From: Amanda Scholes on behalf of Planning.Responses
Sent: 08 October 2019 09:13
To: Planning Scanning
Subject: FW: Planning Consultation on: AL/77/19/HH

Engineers Comments Regarding Surface Water Drainage

NOTIFICATION FROM ARUN DISTRICT COUNCIL
Town & Country Planning Act 1990 (as amended)
Town & Country Planning (Development Management Procedure) (England) Order 2015
Planning Permission for Works or Extension to a Dwelling
APPLICATION NO: AL/77/19/HH
Registered: 12th September 2019
Site Address: 2 Tudor Cottage Tudor Drive Westergate Aldingbourne PO20 3YT
Grid Reference: 493843 105544
Description of Works: Enlarged replacement single storey extension with bathroom and dressing room in roof space.

Site plan 1:250

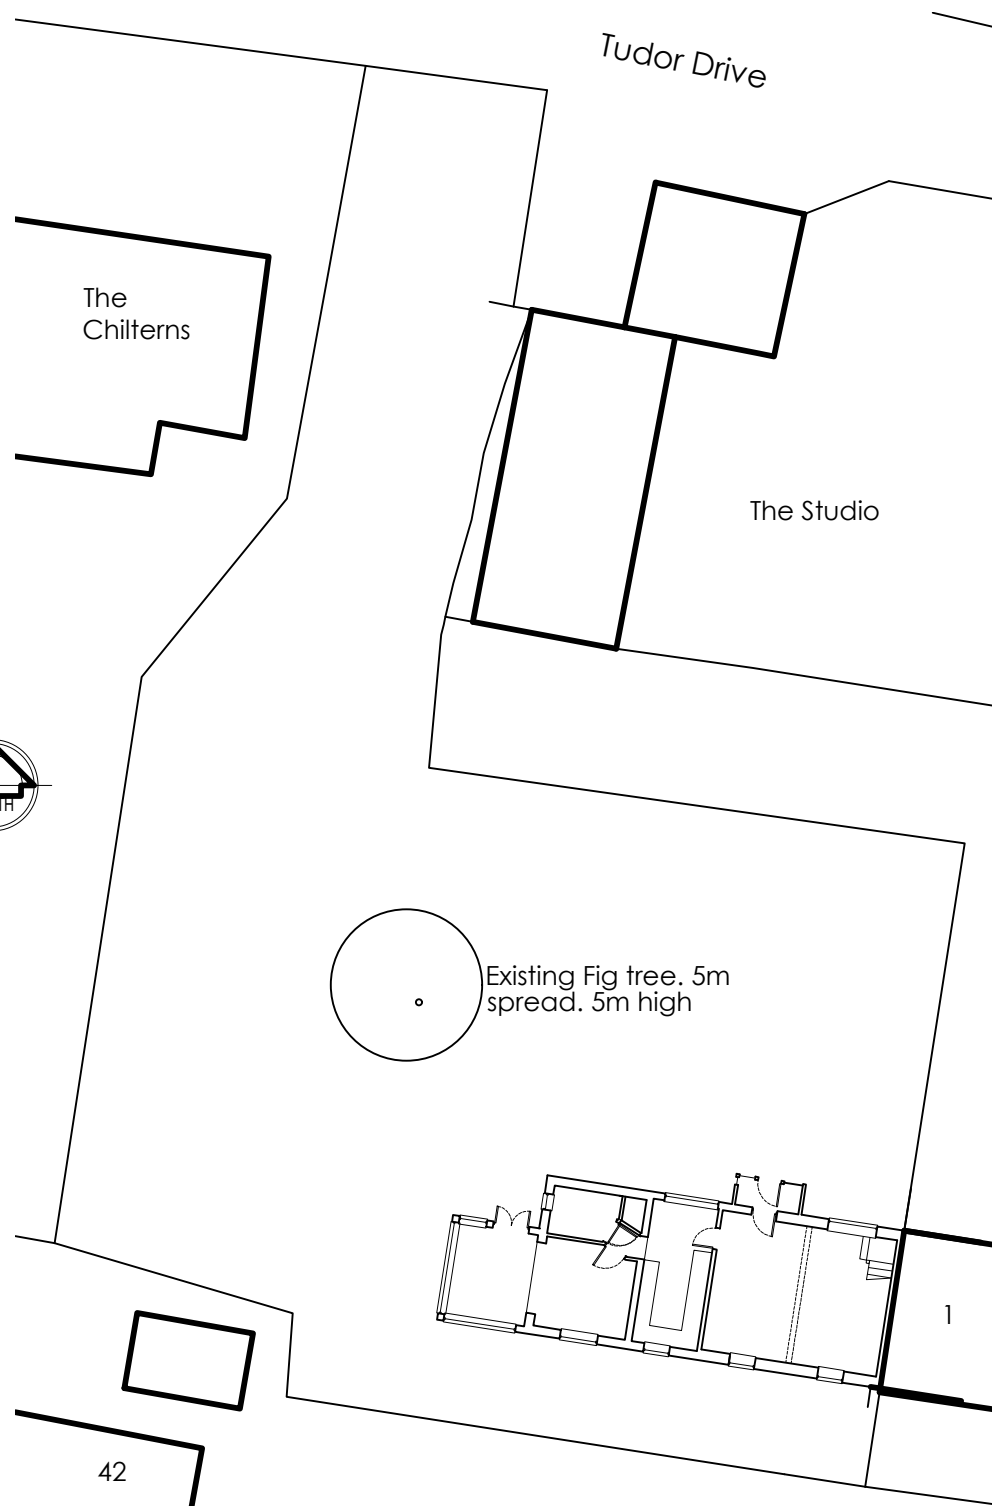
No drainage design has been submitted for this application. Infiltration must be fully investigated.

The site falls within flood zone 3, the Environment Agency should therefore be consulted. We would advocate the use of flood resilient design to minimise the impact of any potential future flooding. The site is bisected by a public foul water sewer therefore Southern Water should be consulted.

If you are minded to approve the application please apply the following conditions to ensure that the development is adequately drained and does not increase flood risk elsewhere.

"Development shall not commence, other than works of site survey and investigation, until full details of the proposed surface water drainage scheme have been submitted to and approved in writing by the Local Planning Authority. The design should follow the hierarchy of preference for different types of surface water drainage disposal systems as set out in Approved Document H of the Building Regulations, and the recommendations of the SuDS Manual produced by CIRIA. Winter groundwater monitoring to establish highest annual ground water levels and winter Percolation testing to BRE 365, or similar approved, will be required to support the design of any Infiltration drainage. No building / No part of the extended building shall be occupied until the complete surface water drainage system serving the property has been implemented in accordance with the agreed details and the details so agreed shall be maintained in good working order in perpetuity."
